From: Simon Davis <Simon.Davis@arun.gov.uk>
Sent: 18 May 2021 16:52
To: Planning.Responses <Planning.Responses@arun.gov.uk>
Subject: FW: Mow Cottage, Felpham - FP/80/21/DOC

From: Sarah Burrow <Sarah.Burrow@arun.gov.uk>
Sent: 18 May 2021 16:48
To: Simon Davis <Simon.Davis@arun.gov.uk>
Subject: RE: Mow Cottage, Felpham - FP/80/21/DOC

- Drainage Layout 2106-SK4 'Mow Cottage' Worms Lane
- Constructional Details 2106-C2 'Mow Cottage' Worms Lane

©	This drawing is the copyright of Robert Clark Associates Limited It may not be copied or reproduced without their written authority		
Scale	As shown	At original	A3
Drawing Number	2106/SK4		Revision -

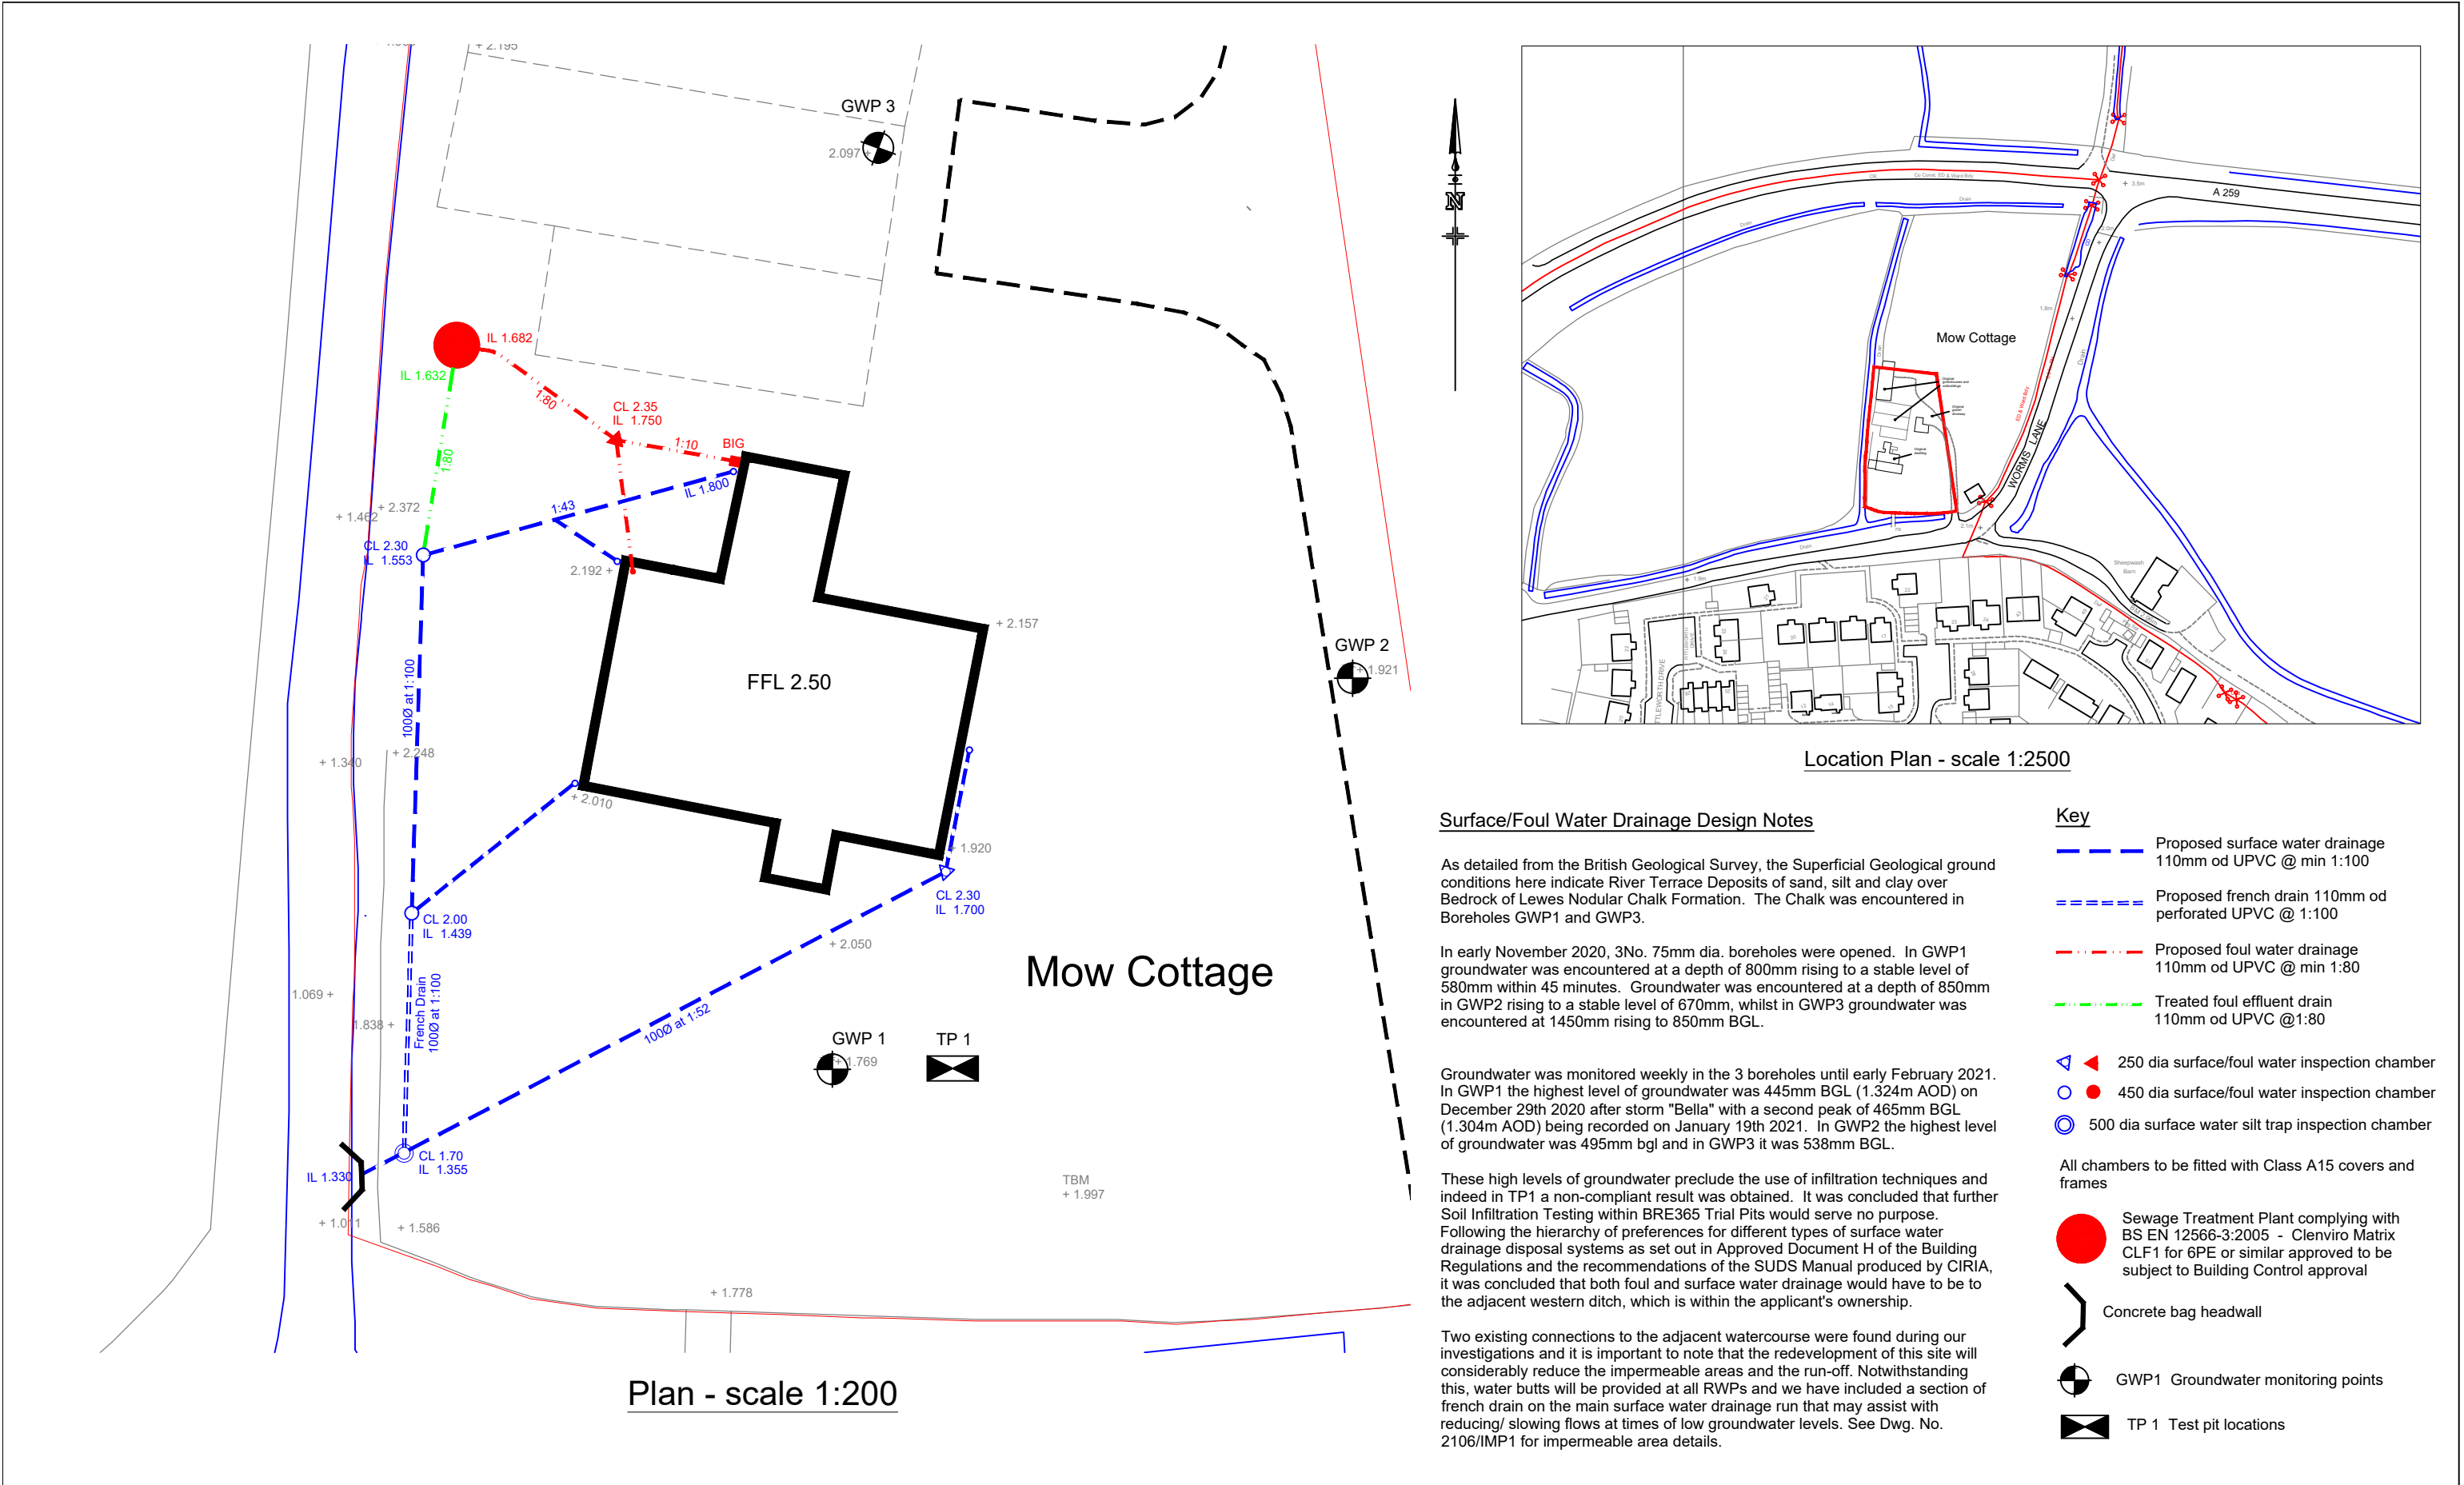
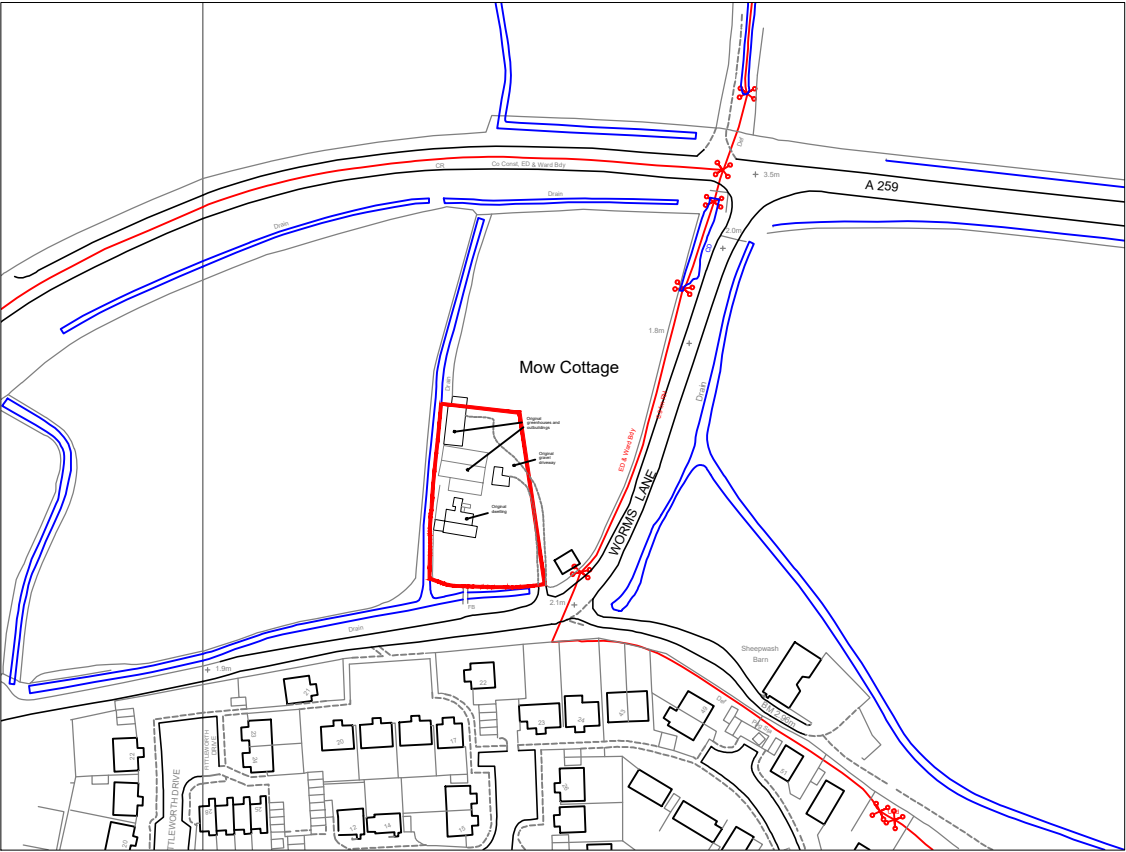
Yes I looked at this earlier. I am happy that they have overcome any of my concerns and they have added the extra details that I have asked for. The only outstanding issue is the Ordinary Watercourse Consent. We will need the consent in order to discharge Condition 6 as this is stipulated within the condition itself. However I am happy to recommend discharge of Condition 5. This is on the assumption that the drainage design does not change as a result of the Ordinary Watercourse Consent process. If the design does change then I would expect a new DOC to be made.
